21 July 2016

Site 9 Sydney Olympic Park, 3 Olympic Boulevard proposed residential development. Expert Judgement related to BASIX alterations

3 Condition 03 - Penthouse Wintergarden  
1 : 20

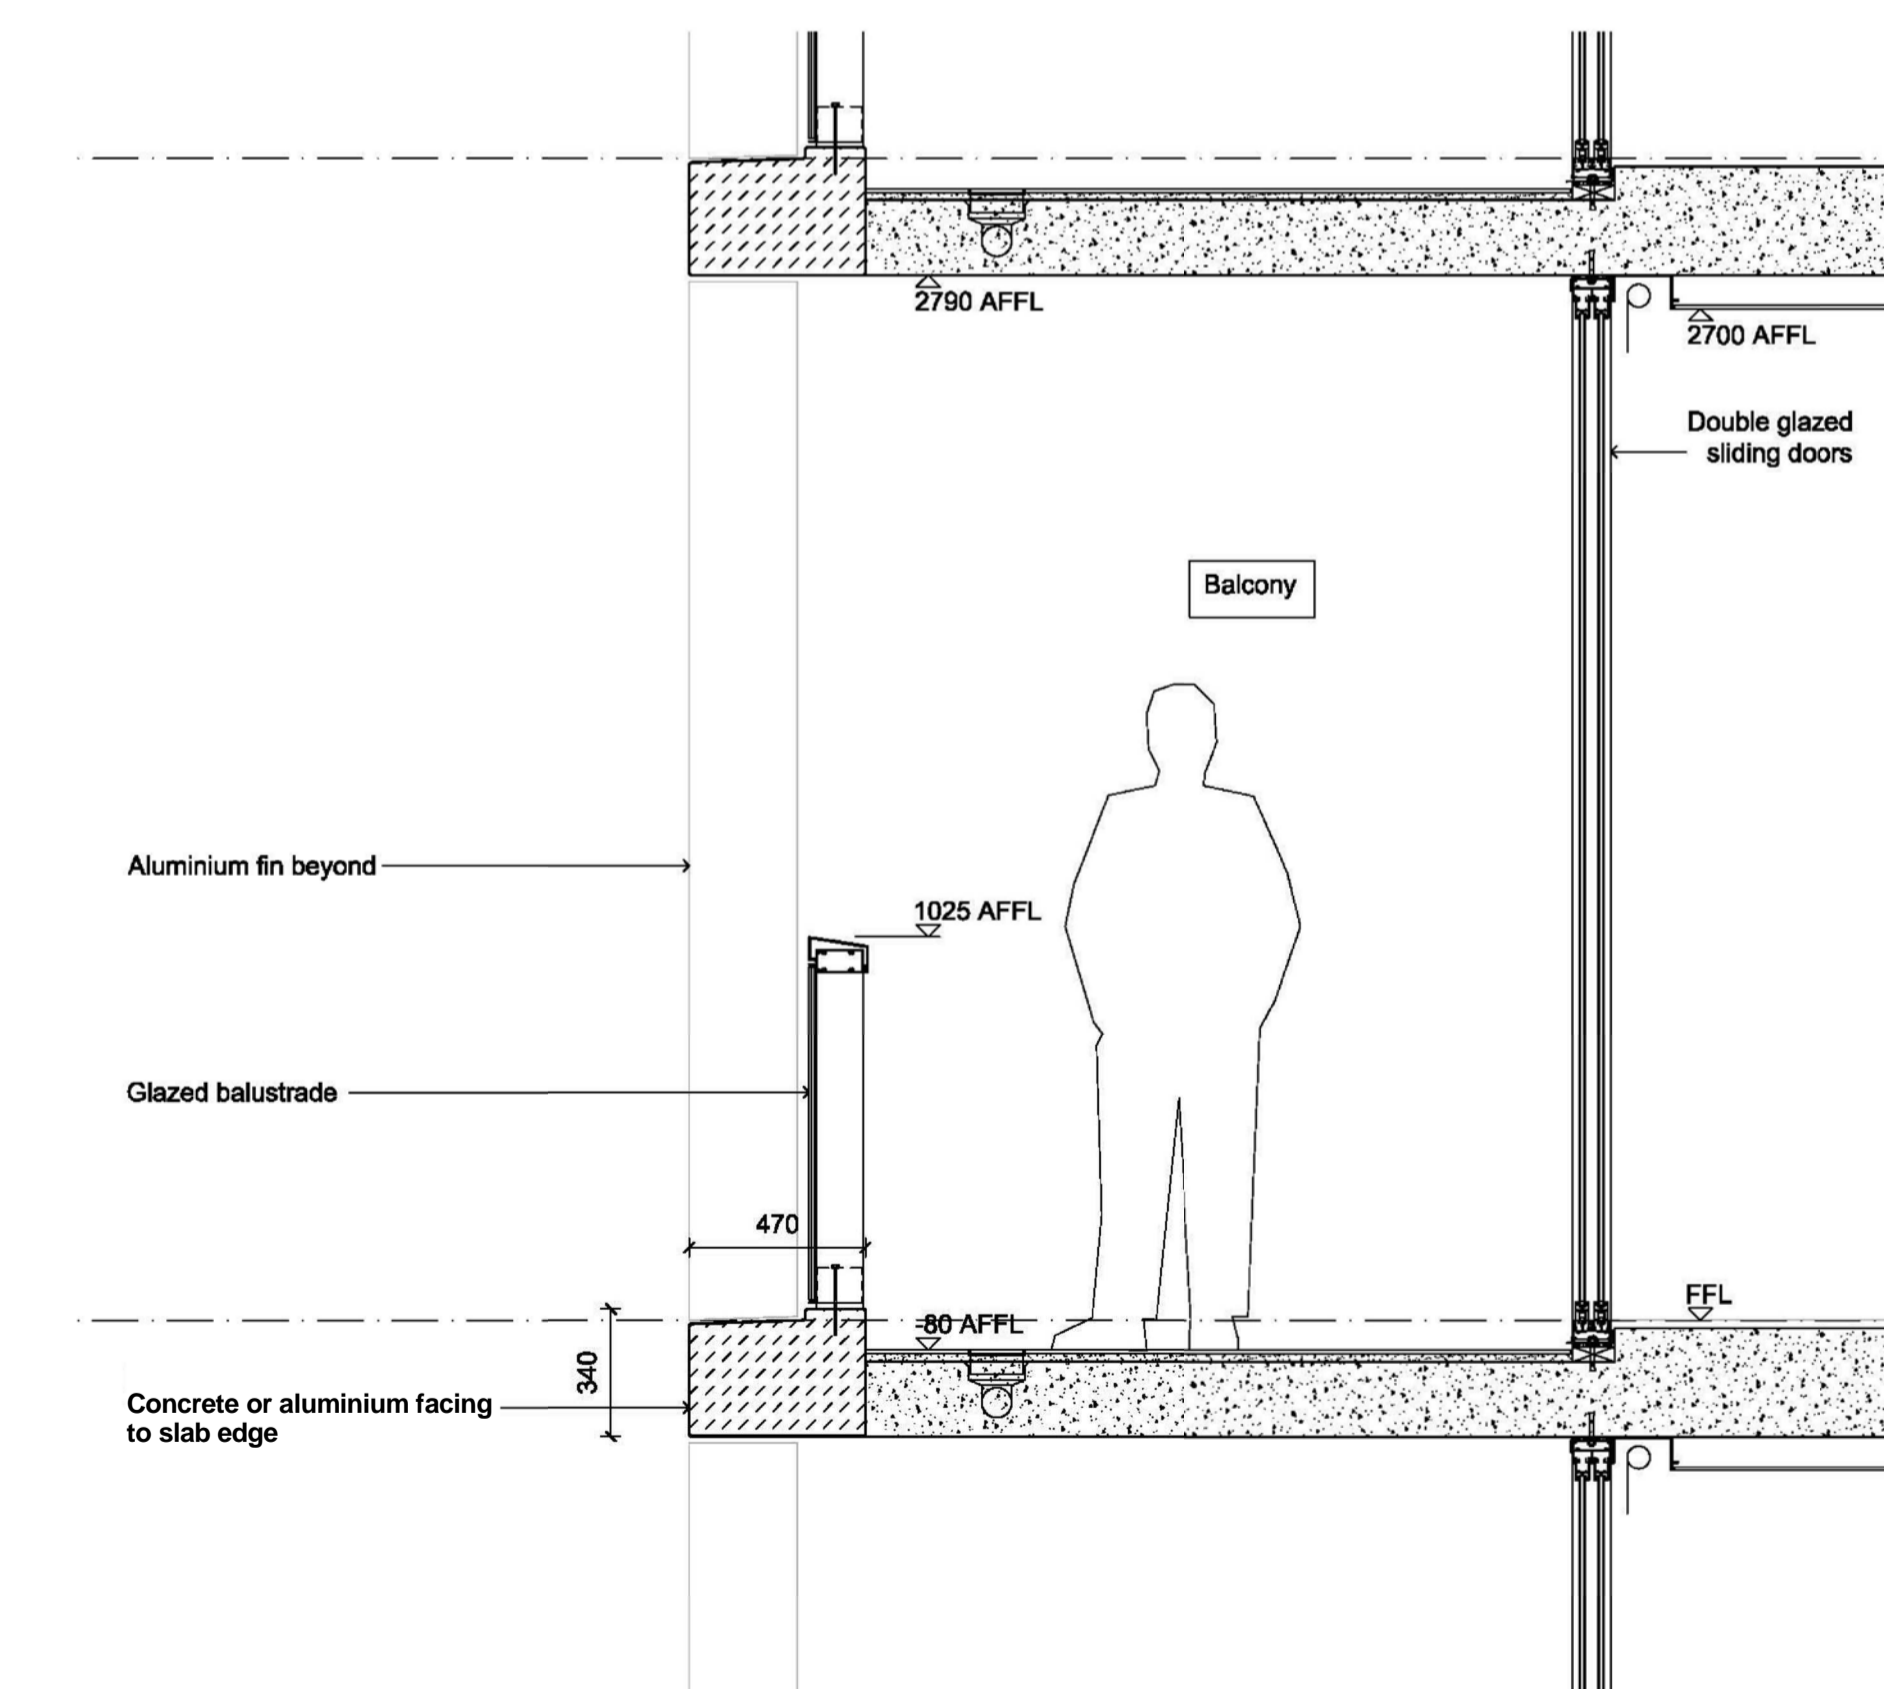
- The key issue is that the Penthouse BASIX thermal comfort performance. The level 39 Penthouse apartment is large but the glass/ area to floor area in similar to the other apartments at approximately 30% glass area ratio to floor area.
- The main north east elevation and the narrow living room is favourable to passive winter heating which will reduce the BASIX winter energy requirements.

- The large overhang shade on the north elevation will allow the penetration of welcome winter sun but will eliminate summer sun.
- The glazing for the façade will need to be a low e double glazing potentially with thermal breaks to improve the overall U value of the façade system. The solar performance (SHGC) of the glass will need to be assessed but we believe it will be a realistic range of SHGC 0.3 to 0.5.
- The deletion of the one north facing apartment to accommodate bicycle storage will not impact the overall BASIX performance.

Overall the alterations will not impact the BASIX energy and water performance and the glass to the Penthouse will have to be assessed using the comfort tool to select the appropriate U value and SHGC performances required for BASIX compliance. The BASIX certificates will need to be revised prior to the Construction Certification stage of the project.
